Our ref: HA/2018/120157/01-L01
Your ref: LU/414/17/PL
Date: 21 February 2018

CHANGE OF USE OF LOWER GROUND FLOOR RESTAURANT (A3 FOOD & DRINK) TO SHOP (A1 SHOPS), DEMOLITION OF EXISTING GARAGE, CONVERSION OF SHOP & RESIDENTIAL SPACE TO PROVIDE 6 NO. ONE BEDROOM FLATS (FIVE ADDITIONAL UNITS) TO INCLUDE FIRST & SECOND FLOOR EXTENSIONS & STAIR TOWER (RESUBMISSION FOLLOWING LU/71/17/PL & LU/243/17/PL).

56-57 PIER ROAD, LITTLEHAMPTON, WEST SUSSEX, BN17 5LP.

Environment Agency position

Drawing Title
Proposed Drawing
Lower and Upper Ground Floor Plans
1/100 @ A3

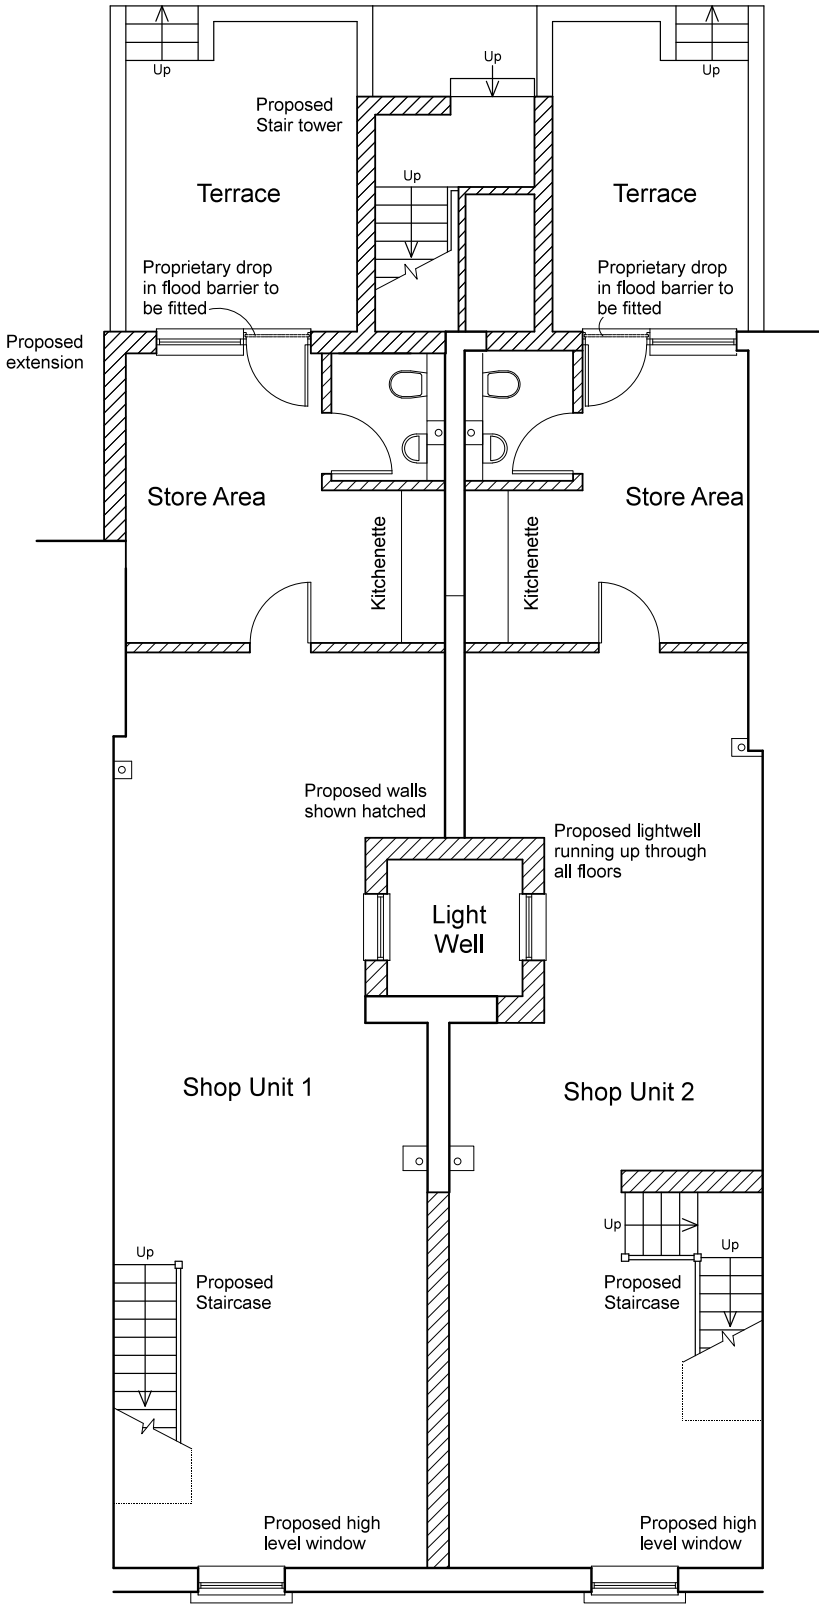
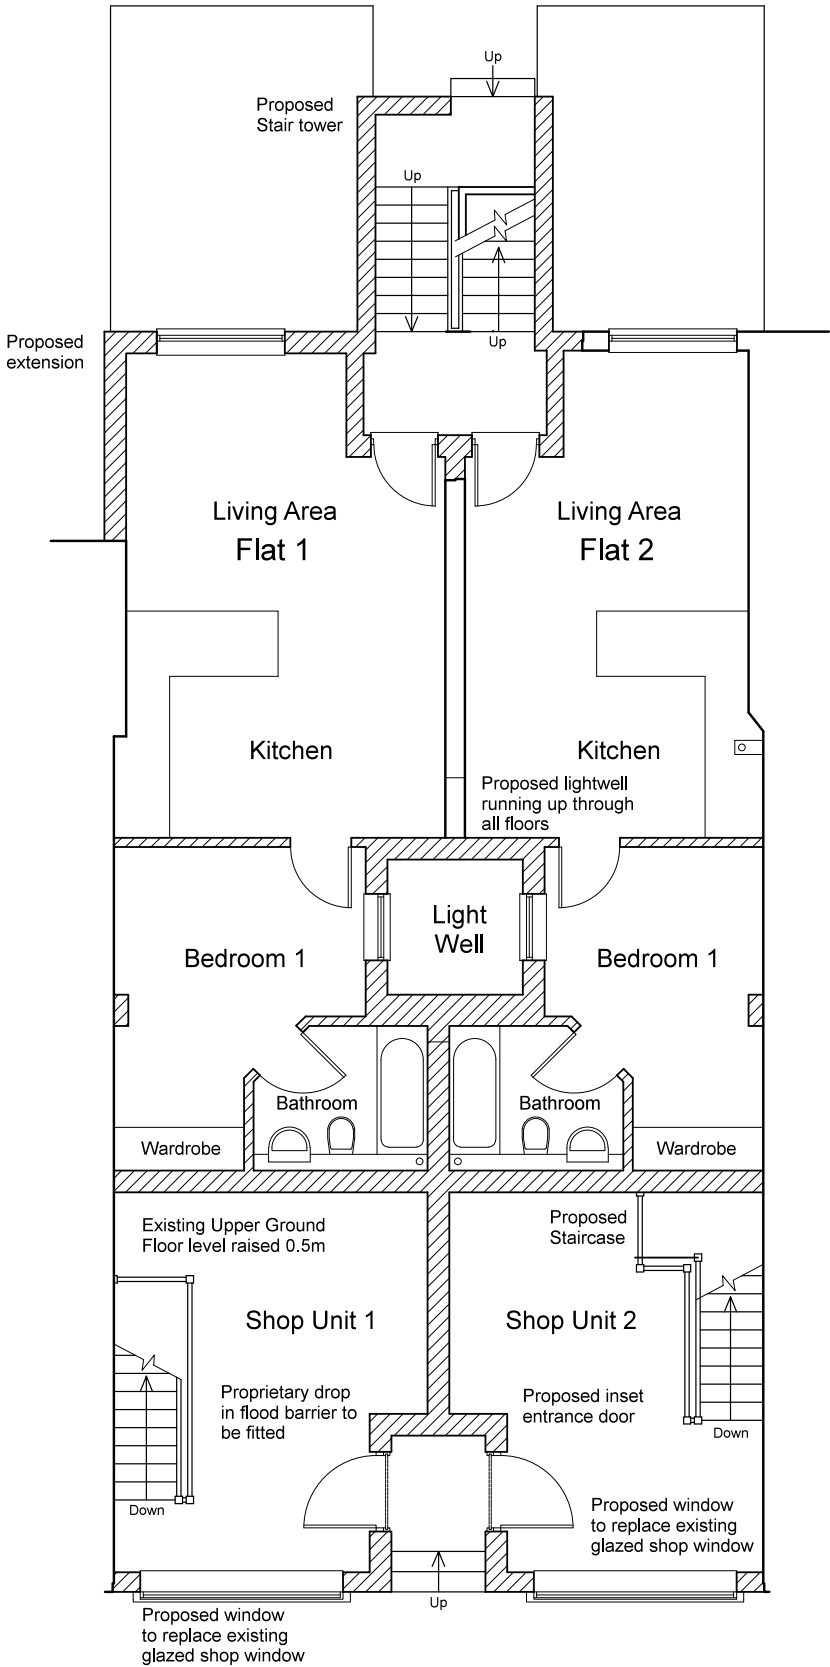
- **No habitable rooms to be located at the lower ground floor.**
- **Finished floor levels are set no lower than 4.3 metres above Ordnance Datum (AOD).**
- **Walls to be internally tanked to 4.94 metres above Ordnance Datum (AOD).**
